DRB Application No.: 07DRB-70397

Project Name: RIVERVIEW PARCELS

**Date:** November 27, 2007  
**To:** Andrew Garcia, Acting DRB Chair  
**From:** Carol Toffaleti, Planner, Development Review Division   
**Subject:** Project # 1006717 / 07EPC-40034 – Dr. Gil Fernandez Dental Clinic

**SITE PLAN**  
SCALE: 1" = 20'-0"

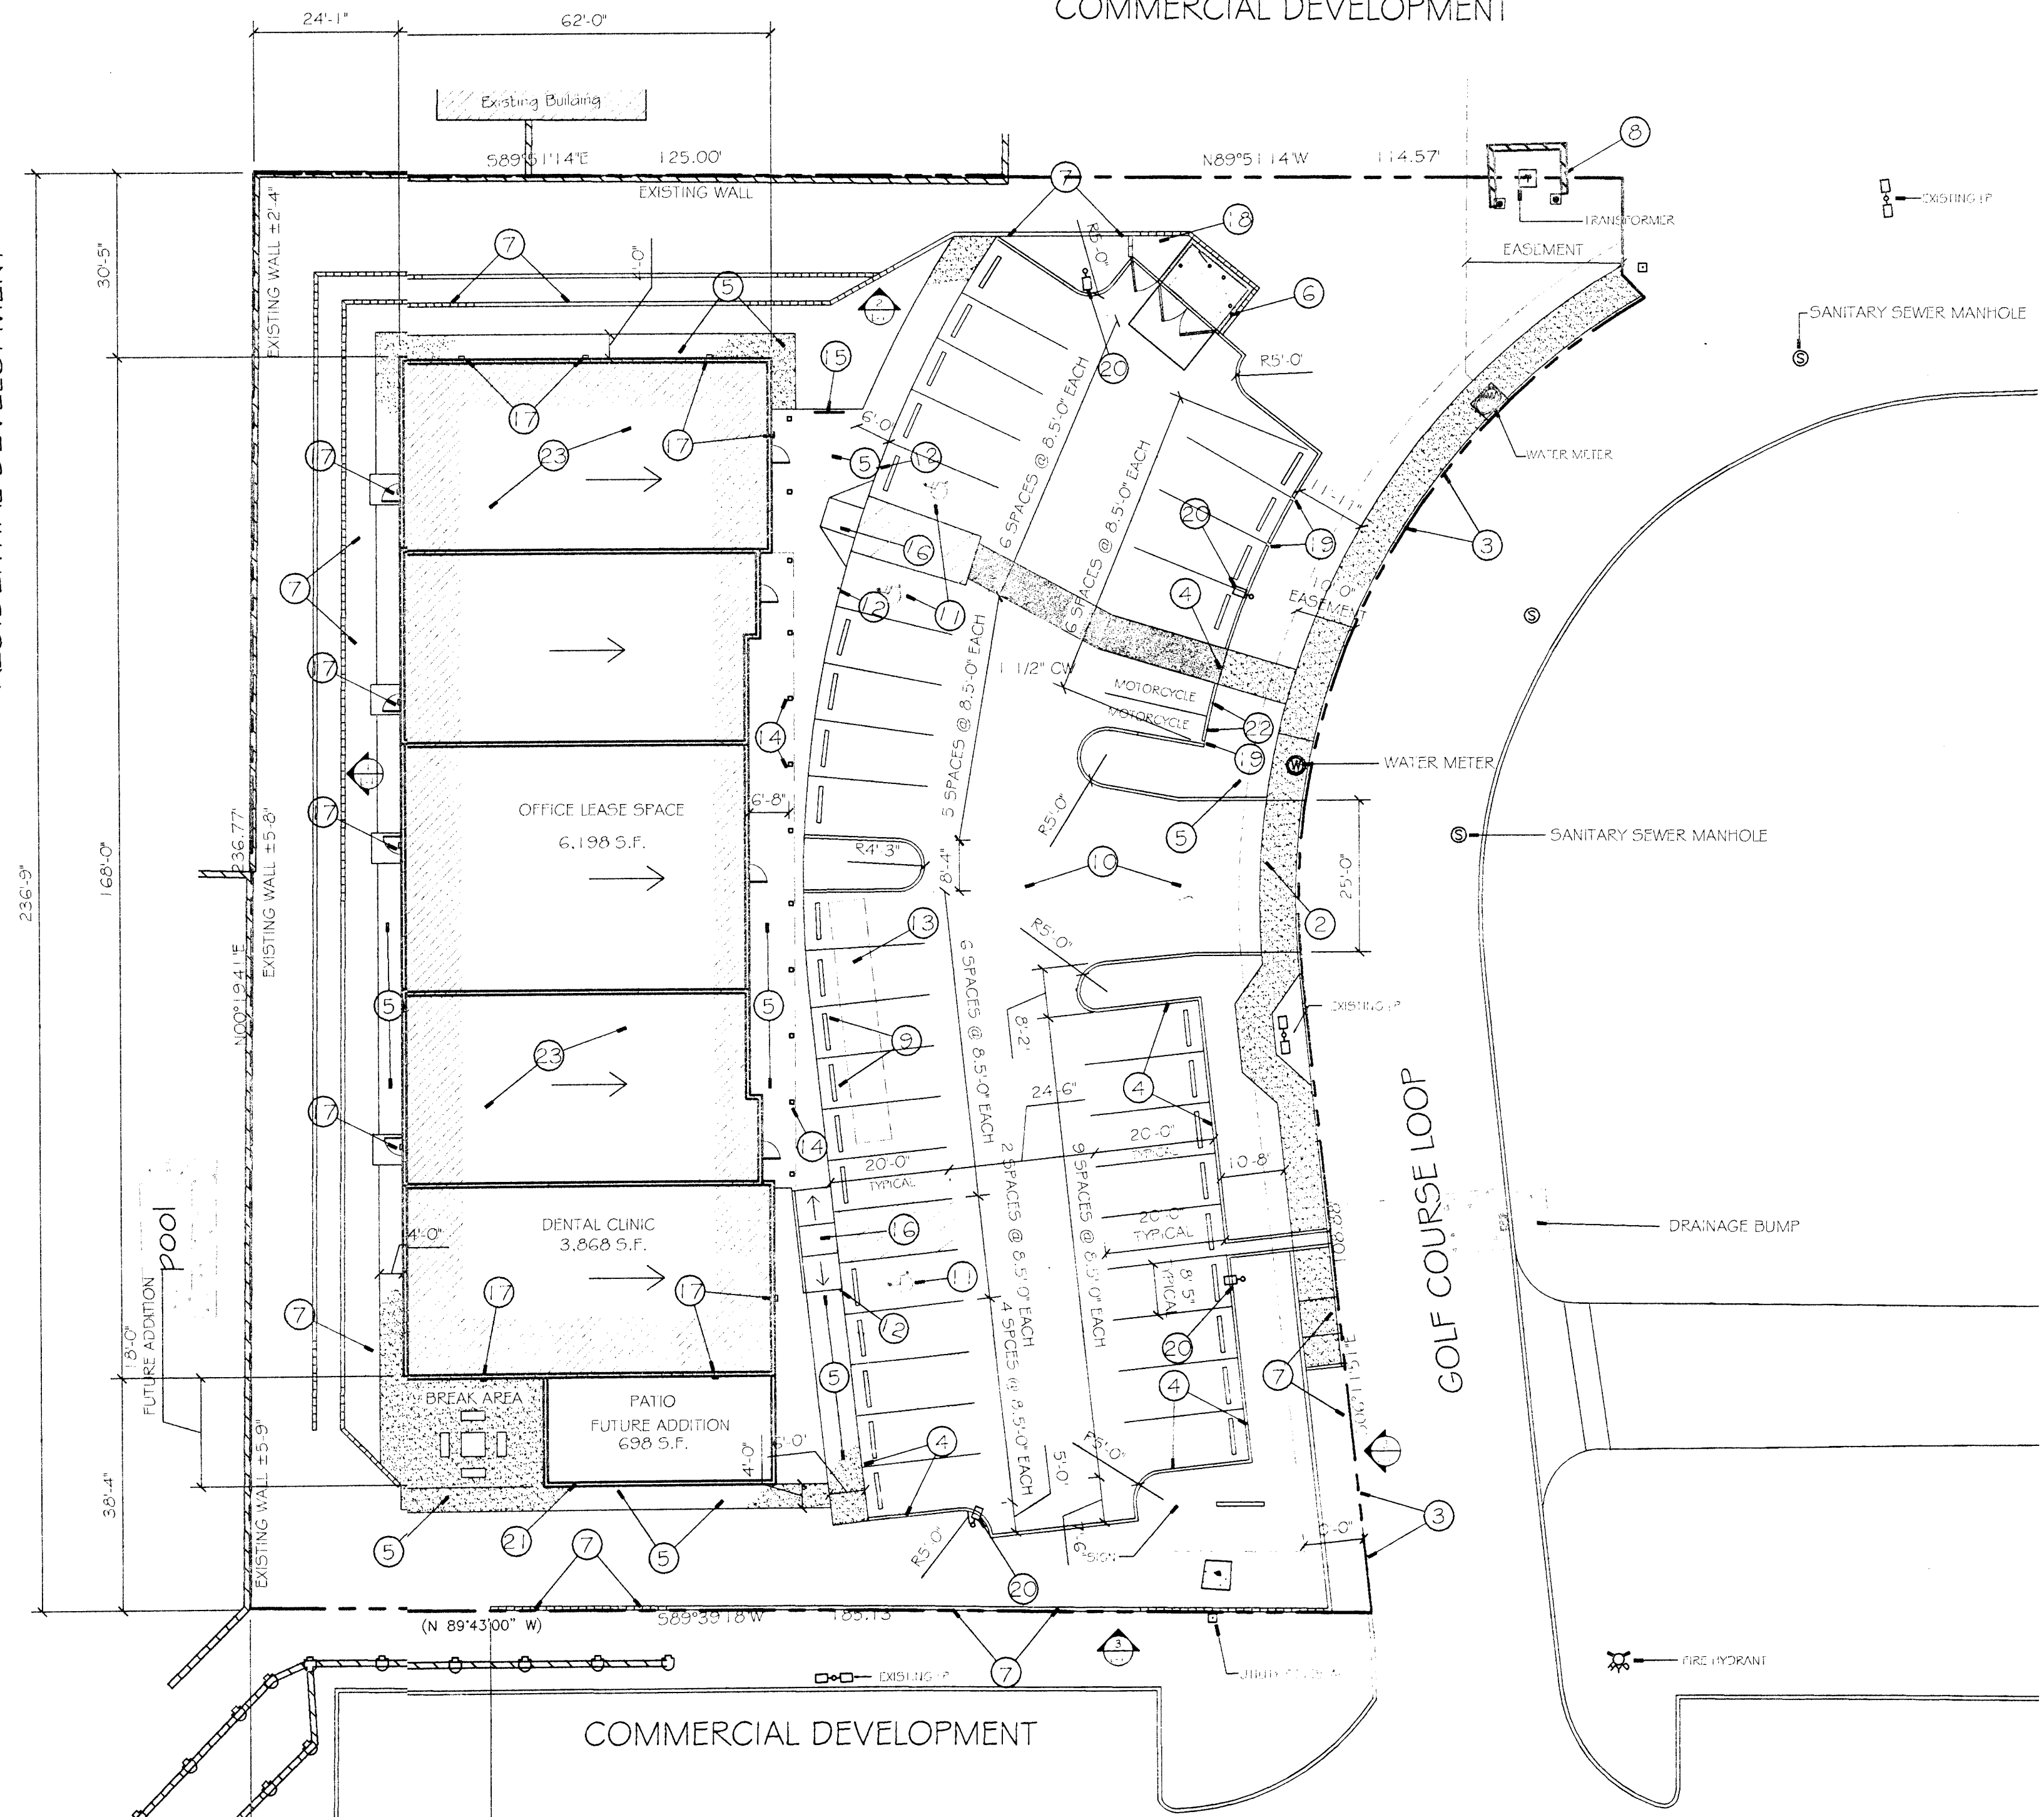
Condition 5 – The 6' clear path along the main façade is provided except for the area around the 2<sup>nd</sup> column from the south side of the building.

**3 H.C. RAMP**  
SCALE: 1/4" = 1'-0"

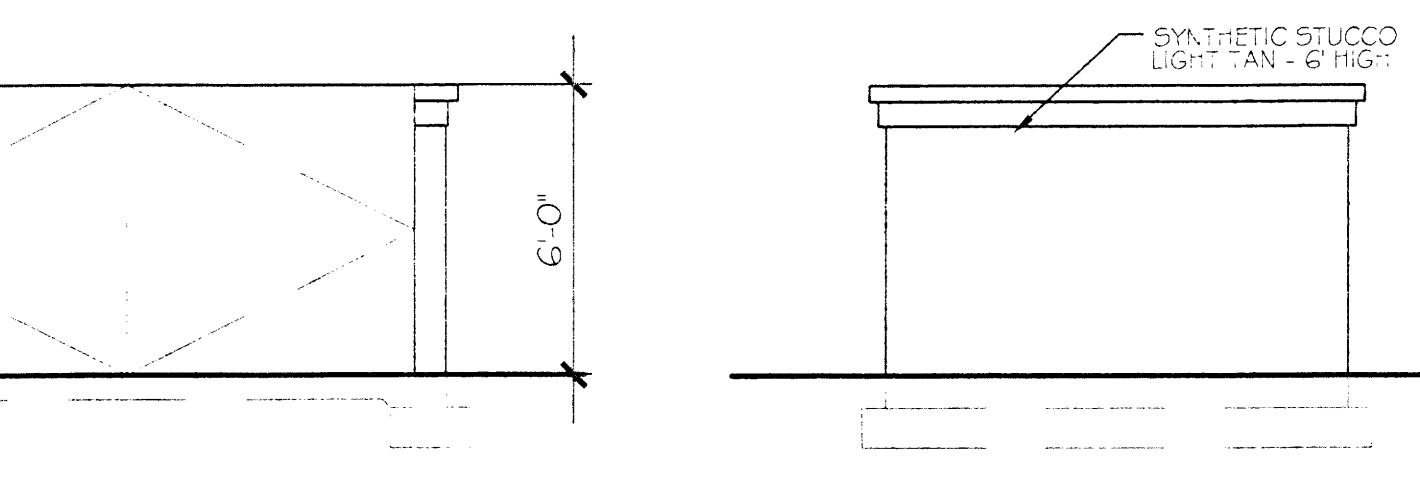
- TRANSPORTATION: Need SW esmt for SW outside ROW; provide max slope on ramp detail - need detail for each type of ramp; build notes, referring to CoA Std #s, needed for all work in ROW; call out width of SW along Golf Course Loop

PLANT LEGEND

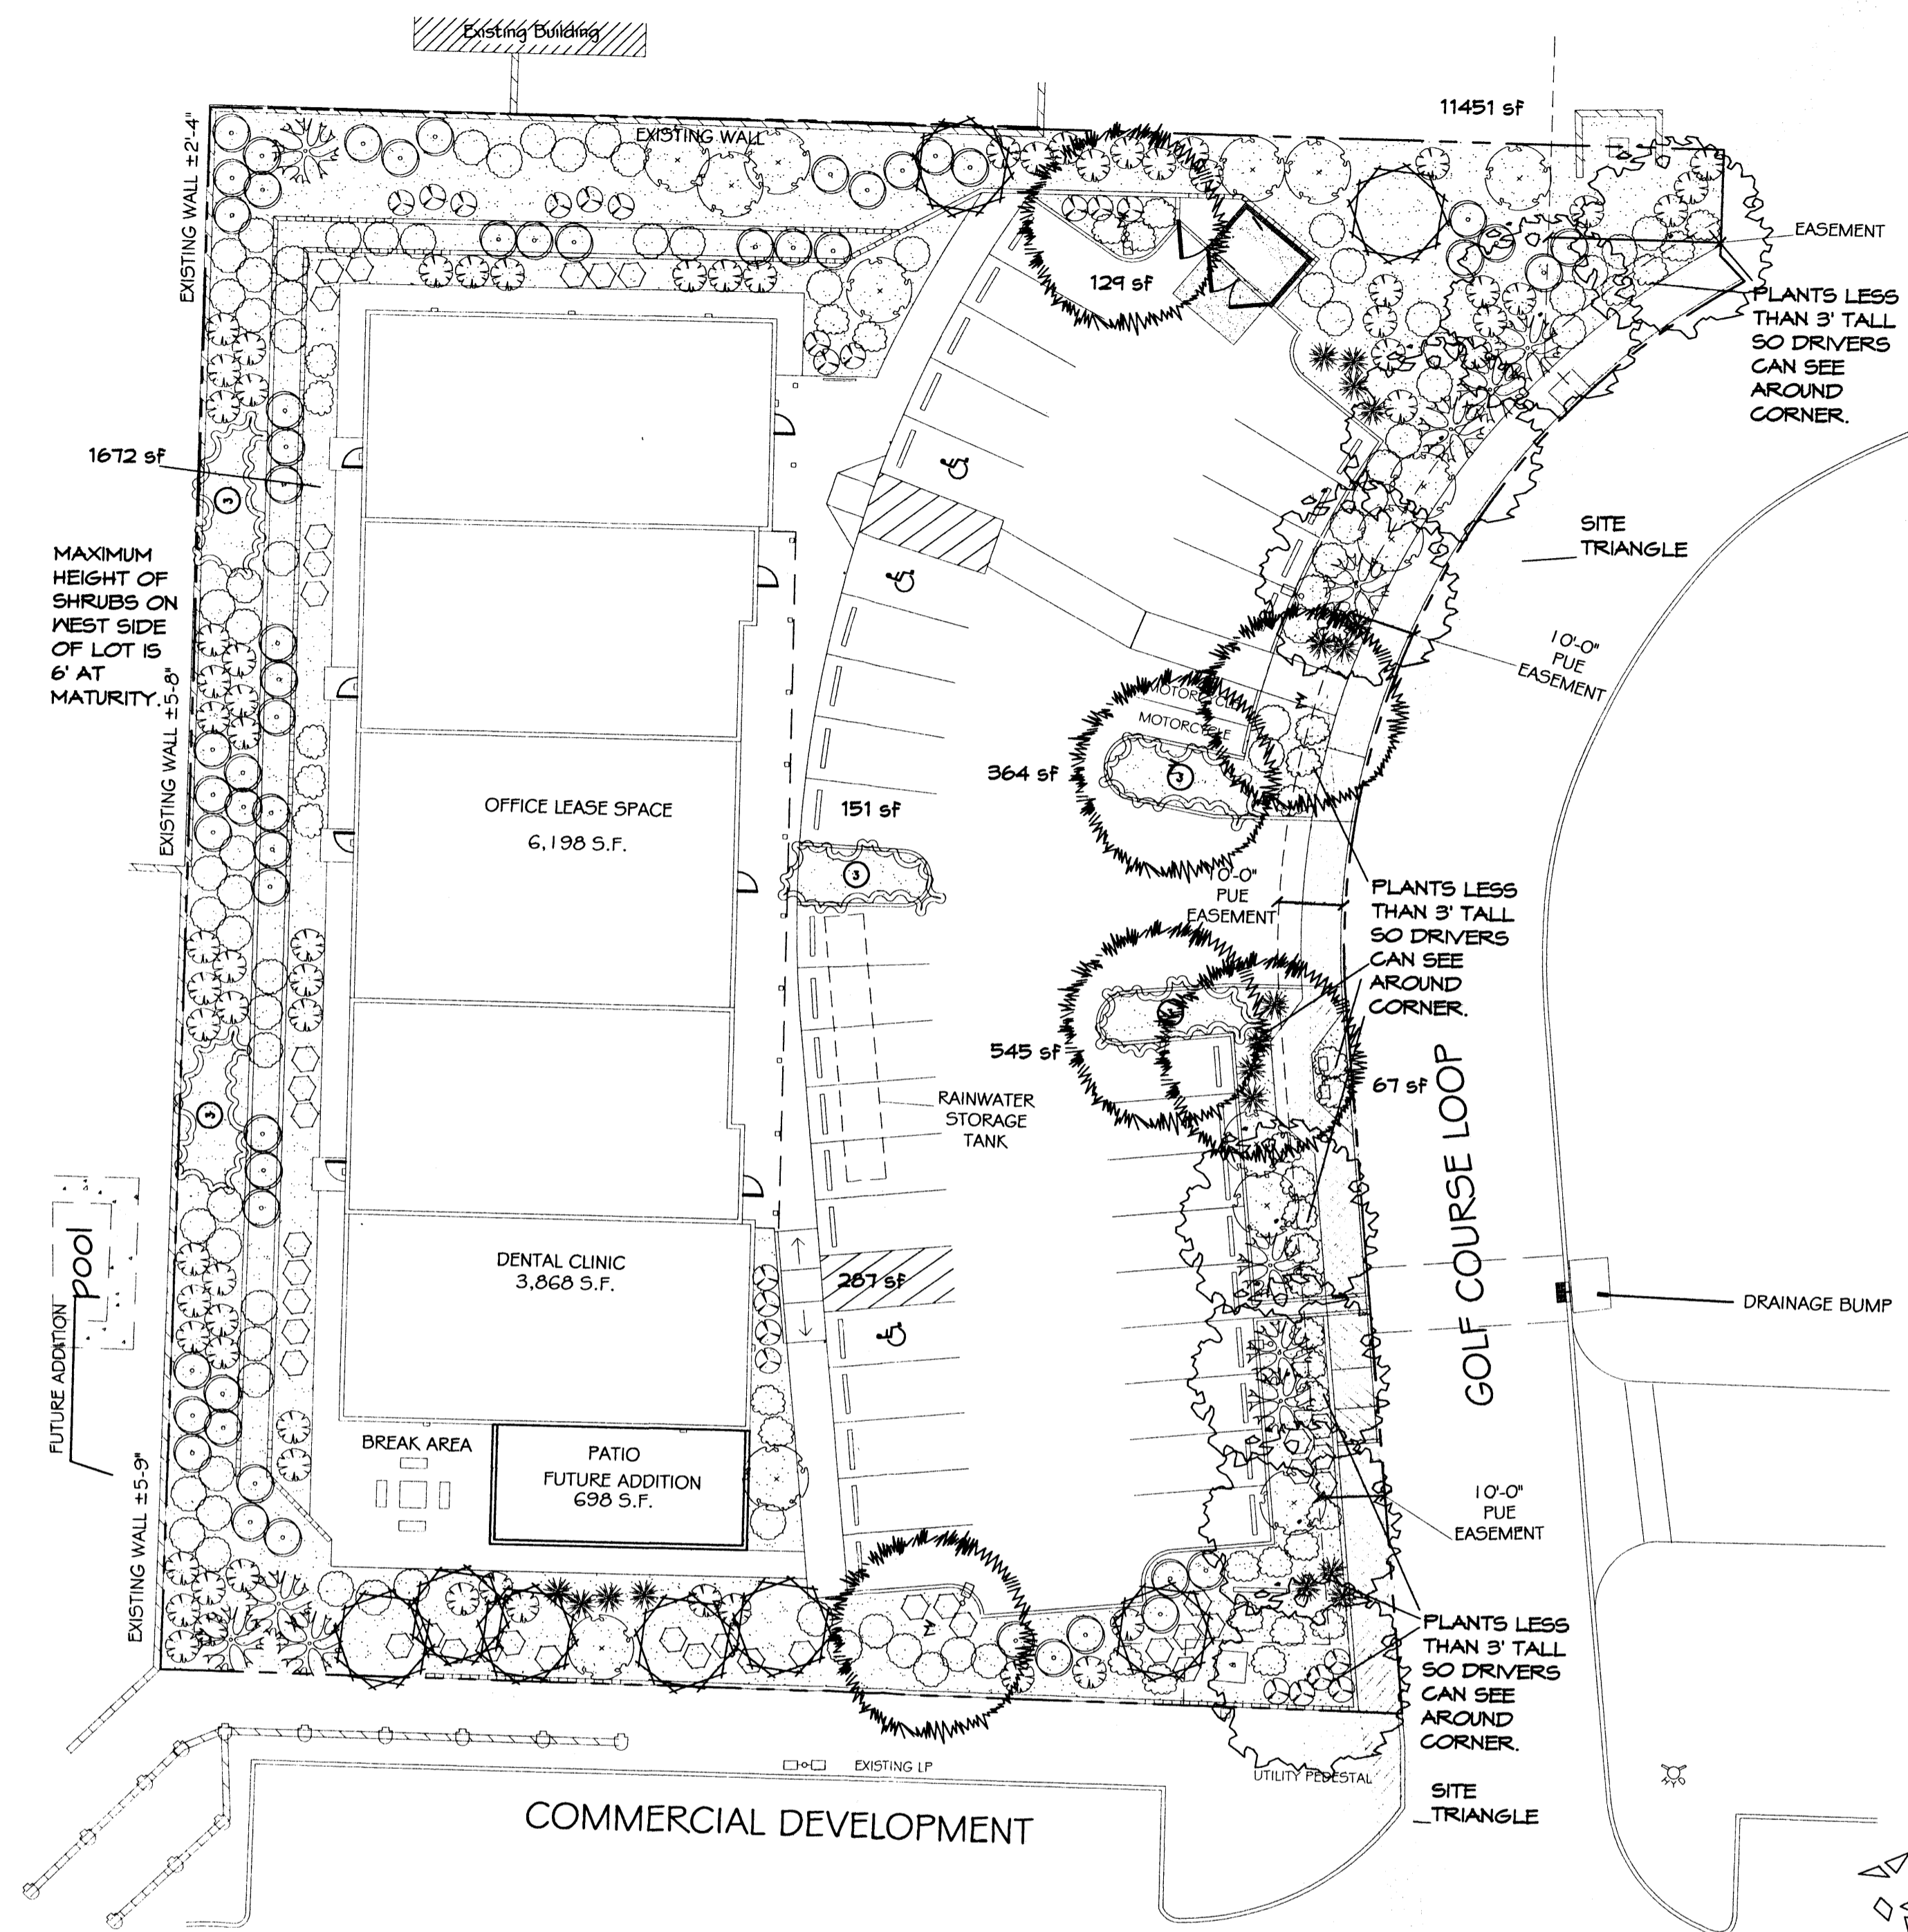
- a. The Bird of Paradise and Broom Baccharis in the top tier of the terrace along the existing north wall and at the southwest corner of the site must be replaced with a shorter shrub or vine. This is to ensure that vegetation at maturity does not exceed the height of the existing walls and obstruct views from the residential area, and to the escarpment.
- g. The note must include a title so that it is clear what it refers to, i.e. Rainwater Storage Tank. In order to meet the intent of the EPC, the irrigation plan must also show how rainwater will be conveyed to the tank and then distributed to the irrigation lines.

EAST ELEVATION  
SCALE: 1/8" = 1'-0"

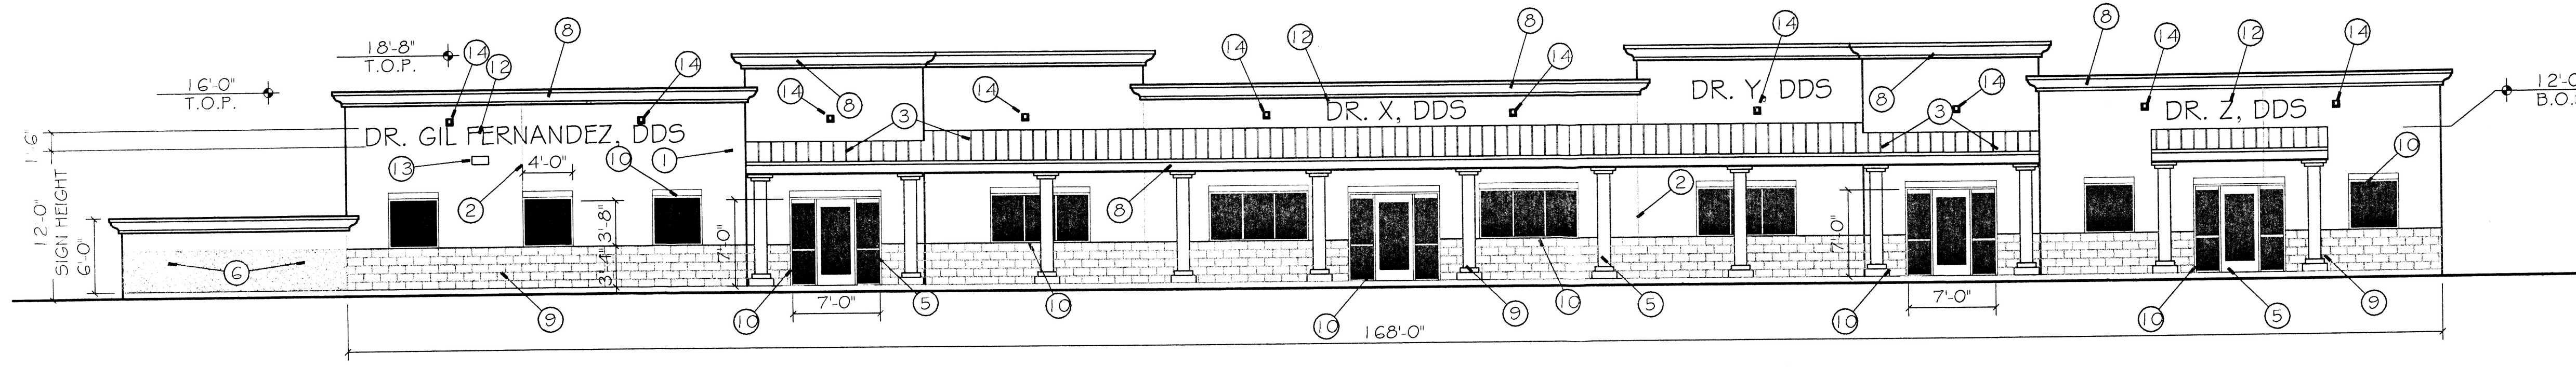
Condition 11 – Although the condition has been met, the split face CMU that it replaces is not properly keyed (see keyed note #9 re. east elevation). This must be corrected.
